From: Amanda Scholes on behalf of Planning.Responses
Sent: 18 July 2018 08:42
To: Planning Scanning
Subject: FW: LU/82/18/L - Littlehampton Quaker Friends Meeting House, 23 Church Street, Littlehampton

From: Russell McCourty [REDACTED]
Sent: 17 July 2018 11:57
To: Anita Gardner
Cc: Martyn White
Subject: RE: LU/82/18/L - Littlehampton Quaker Friends Meeting House, 23 Church Street, Littlehampton

From: Anita Gardner [REDACTED]
Sent: 12 July 2018 16:28
To: Russell McCourty [REDACTED]
Subject: FW: LU/82/18/L

FRONT ENTRANCE

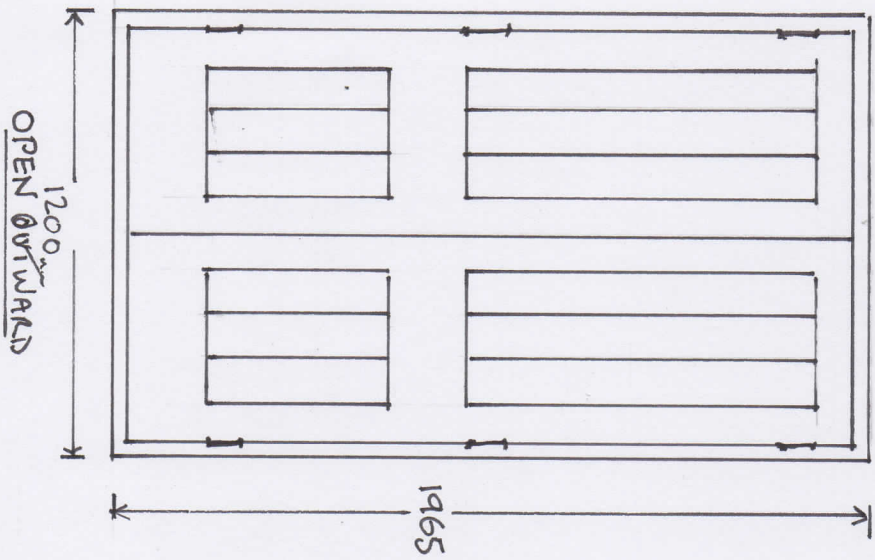
The proposed ramped access is considered acceptable, if it can be achieved on the manner described in the Design and Access statement. Samples of materials described (brickwork and non-slip pavers), should be subject to condition. It is assumed that guarding or handrails would also be required. These would also be subject to condition if the application is successful.

It is noted that the proposed glazed entrance would be visible on the front elevation to the property, but that the glazed nature would limit this. Having read the statements provided, it is not clear why such a feature is required. The glazed nature of the works would mean that the impact of the structure would be reduced, and it is light weight in nature for its impact to be minimised. The use of aluminium is questioned as this does not reflect the status of the building and the use of alternative materials should be considered.'

- Yes the new sink supply and drainage will be wall-mounted; it would not be appropriate to chase in any new pipework or cabling in this building;
- Noted regarding ramped access;

- The new glazed porch structure is intended to enhance the comfort of wheelchair users entering the building, notably in adverse weather conditions by providing better protection before entering the main building. It has been deemed by the regular occupiers of the building that the existing felt flat roof canopy structure is insufficient as it provides negligible shelter or protection from anyone that has any mobility issues entering the building. Additionally we feel the existing felt canopy is a detriment to the frontage of the building, and it has been suggested that a high quality aluminium glazed structure would be more aesthetically pleasing as a main entrance. However, if a material other than aluminium is deemed necessary by yourselves for the frame, then we would be open to discussion regarding alternatives that may better reflect the status of the building (understanding, as always, that any comments made by yourselves are given without prejudice).
